Address: 43 Plover Mills Huddersfield HD3 3ZF

Application number: 2021/93212	
What is the application for?:	Erection of single storey rear extension
Address of the site or building:	45, Plover Mills, Lindley, Huddersfield, HD3 3ZF
Postcode:	HD3 3ZF

Dwg No. 2120 - 01

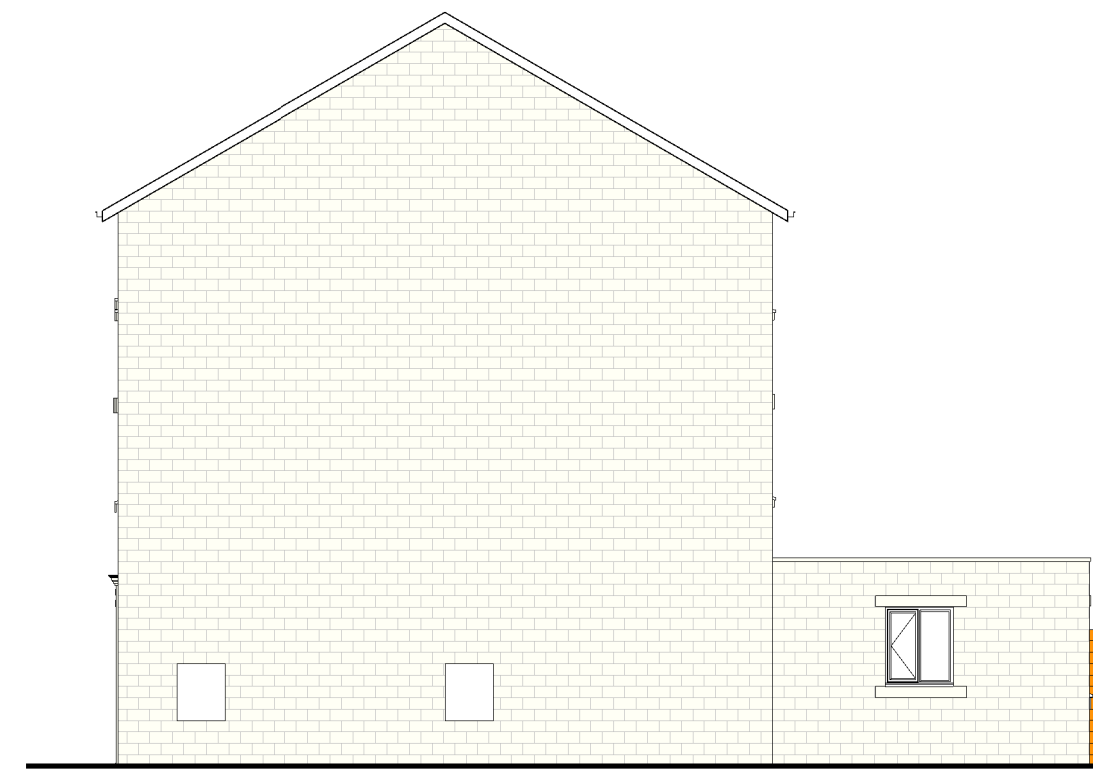
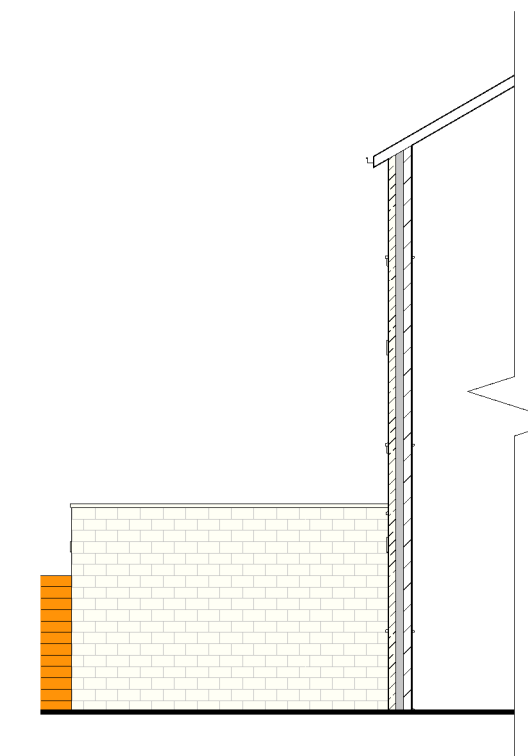
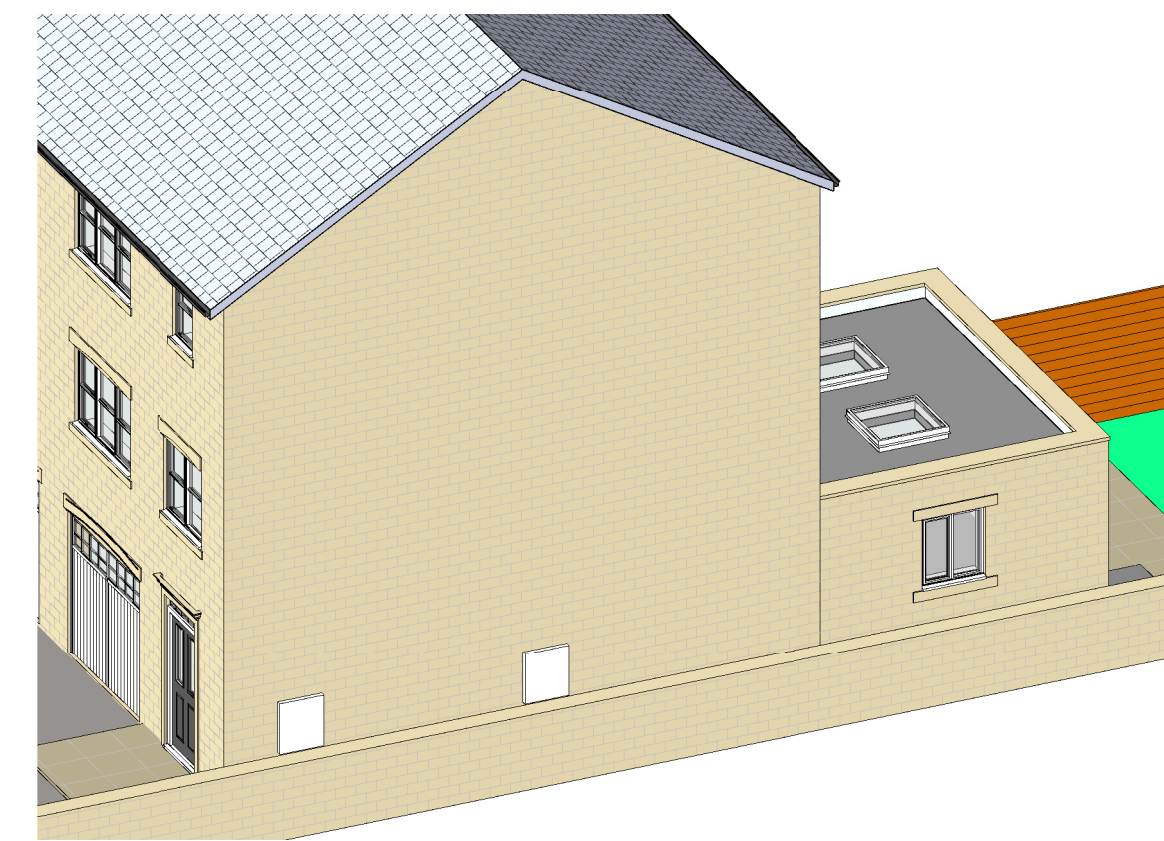
Type of comment: An objection	
Do you wish your comments to be published on the website anonymously?	No
We are an adjoining property to the planning application and feel the proposed extension would significantly adversely affect the aesthetic and character of the area due to the excessive size of the extension. The area is already well developed and further development, particularly on this scale, would appear overbearing and create the impression of severe overcrowding and loss of green space. This would also set a dangerous precedent if all properties were to extend nearly halfway in to their garden, creating an oppressive density of buildings. Due to the height of the side elevation, we would also lose natural light into the downstairs of our property, principally our kitchen window, but it would also overshadow the garden to a large degree. Fences are used to form the boundaries between properties, such a large wall would be out of keeping with the character of the area. The proposed flat roof is also not in keeping with the exclusively pitched roofs of the estate.
